CITY OF PORTLAND

BUILDING PERMIT

Job ID: 2012-02-3327-ALTR

has permission to Build 24' x 25' detached garage

Arthur Ellis	
BRUCE R. BOWMAN, Inc. Professional Land Surveyor 48 Mill Road Cumberland, Maine 02939	
Date: 8-9-93	Job: 213-20
Drawn By:	Scale: 1" = 30'

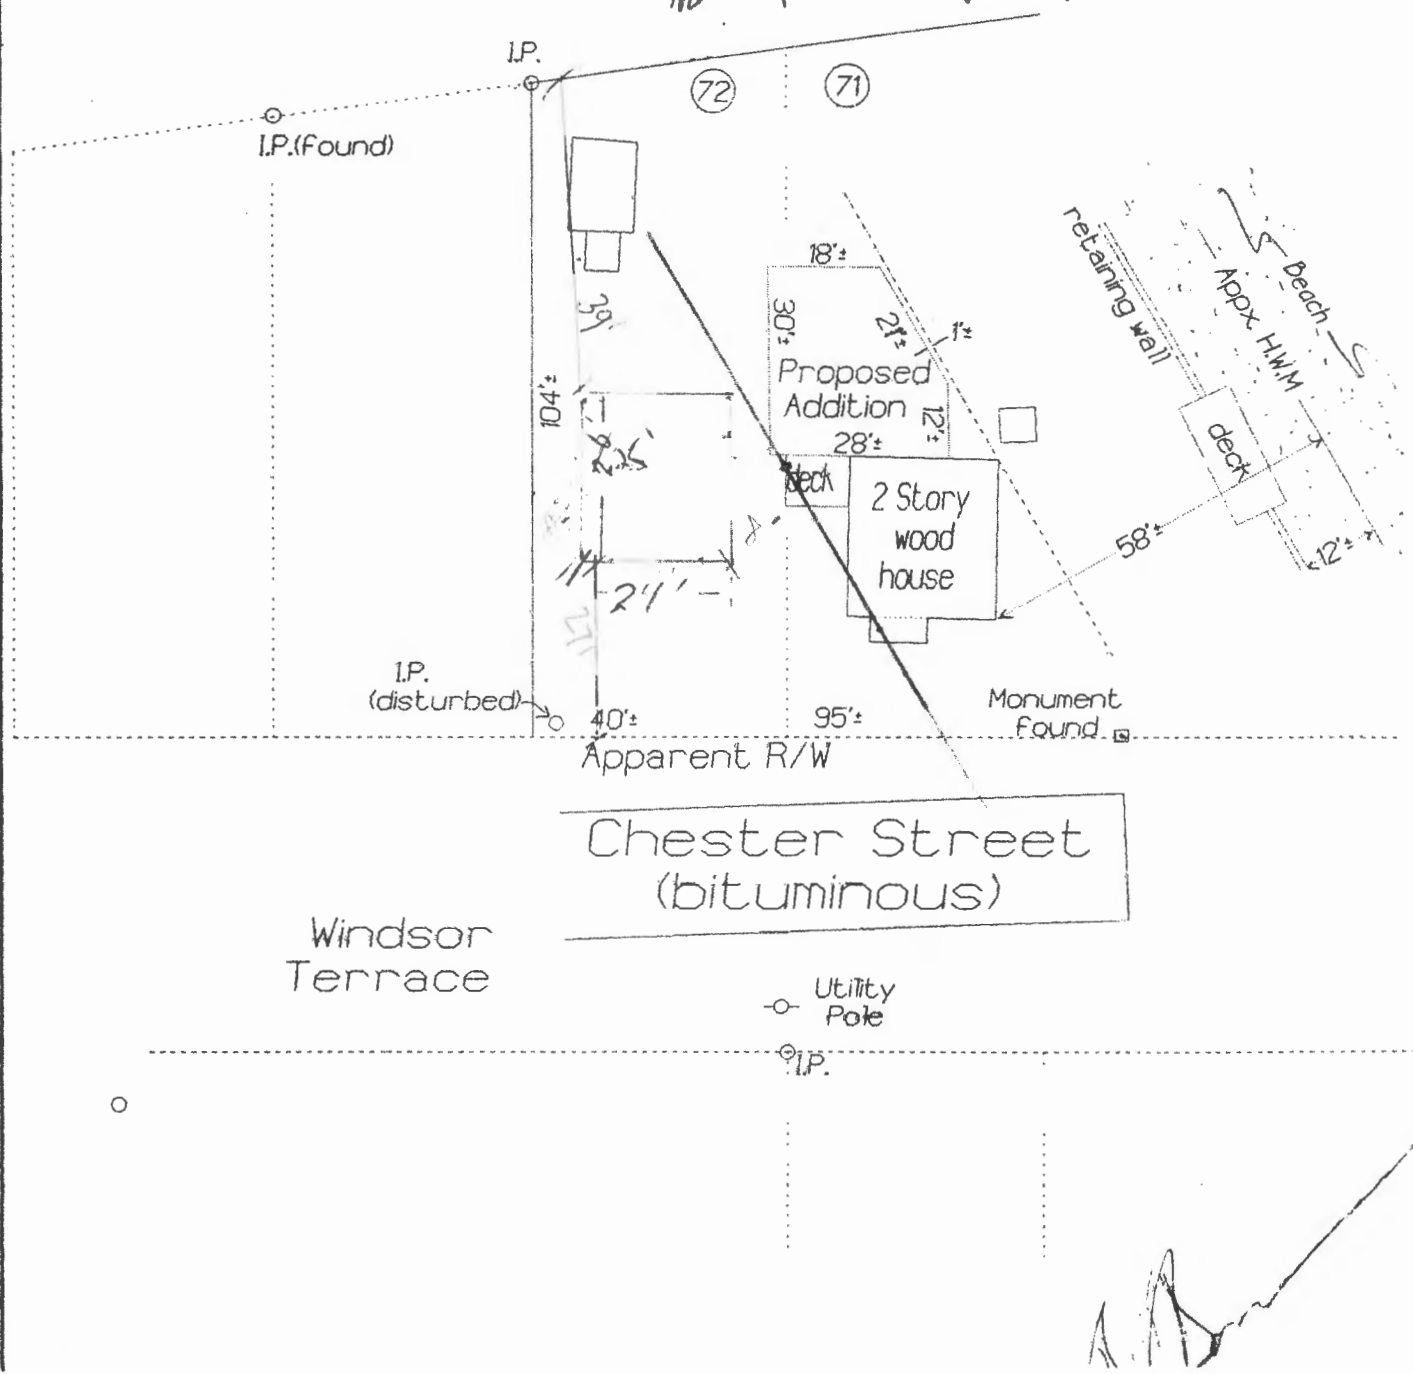
The garage must be reduced to 24' x 25' in order to be placed on a slab. Otherwise, there must be a 4'-0" frost wall.

REAR: 25' min - 39' scaled
 FRONT: 25' min - 27' scaled
 Side: 8' min & show

Bldg no higher than 18' from grade to mid point of roof

- Neighbors also complained that footprint of house shown on plot plan is not accurate - can the inspector confirm the ^{footprint} ~~size~~ of the house?

24 X 26 DETACHED

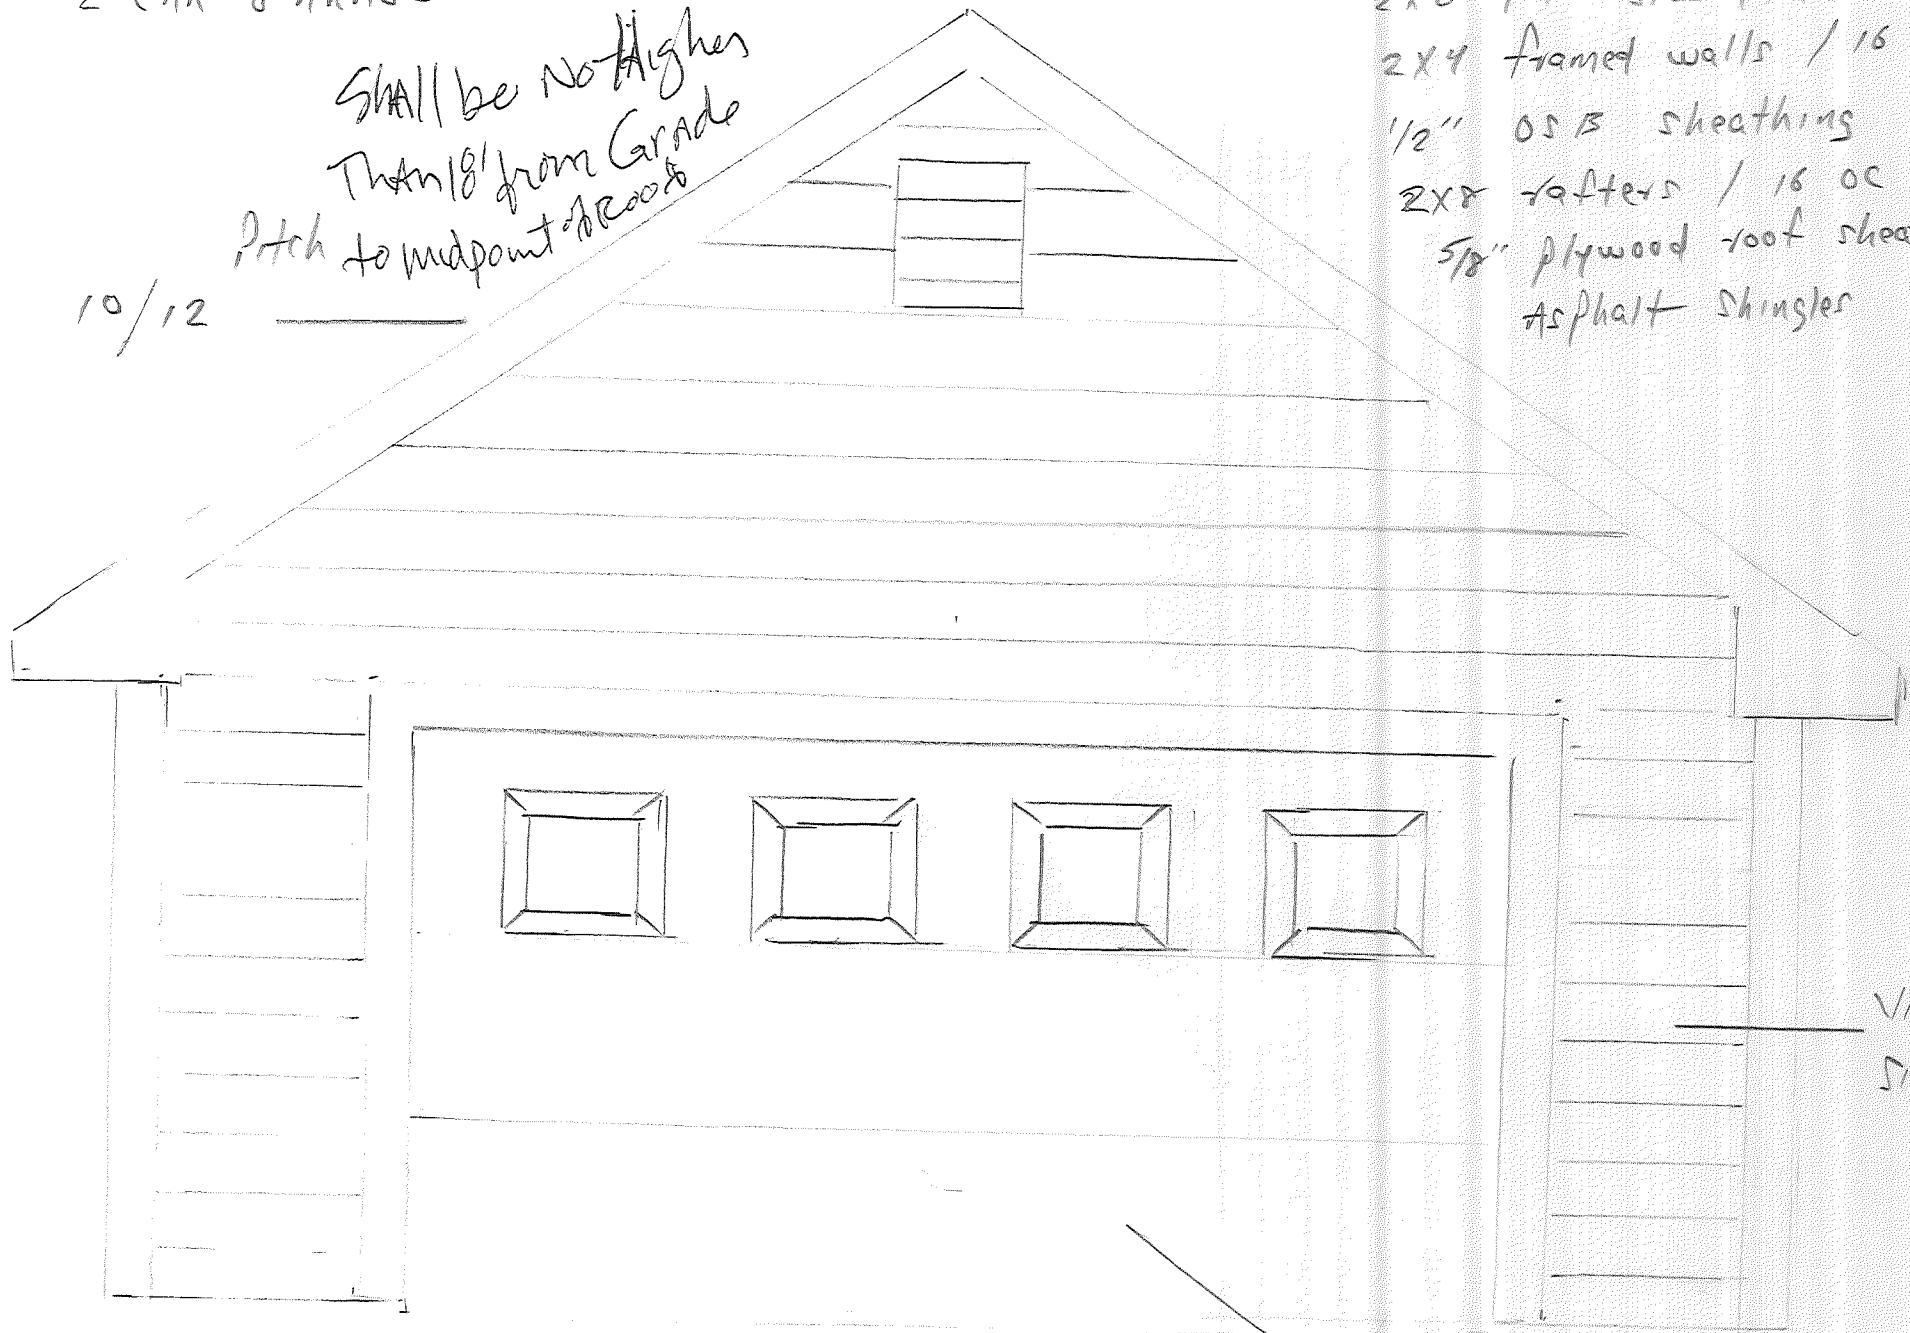
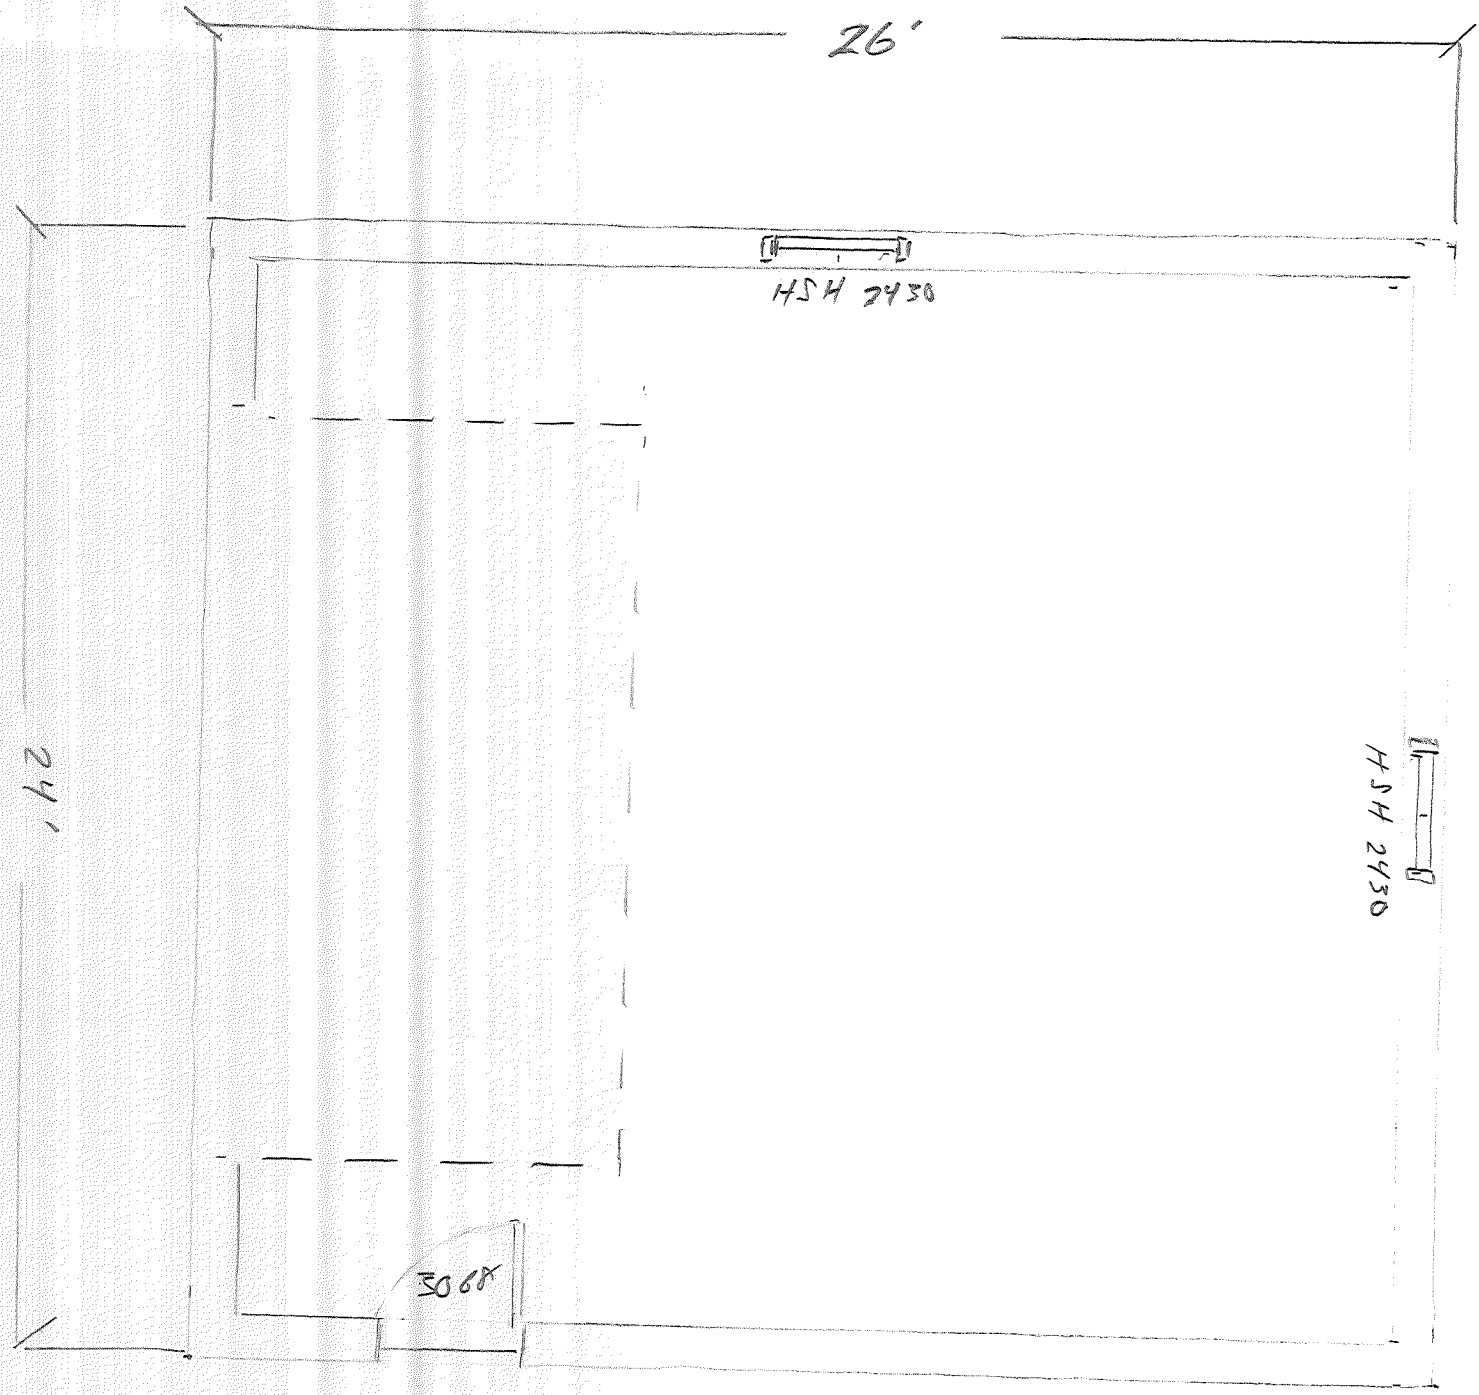
SHALL BE NO HIGHER THAN 18' FROM GROUND WITH 40 WINDPOW AIRCRAFT
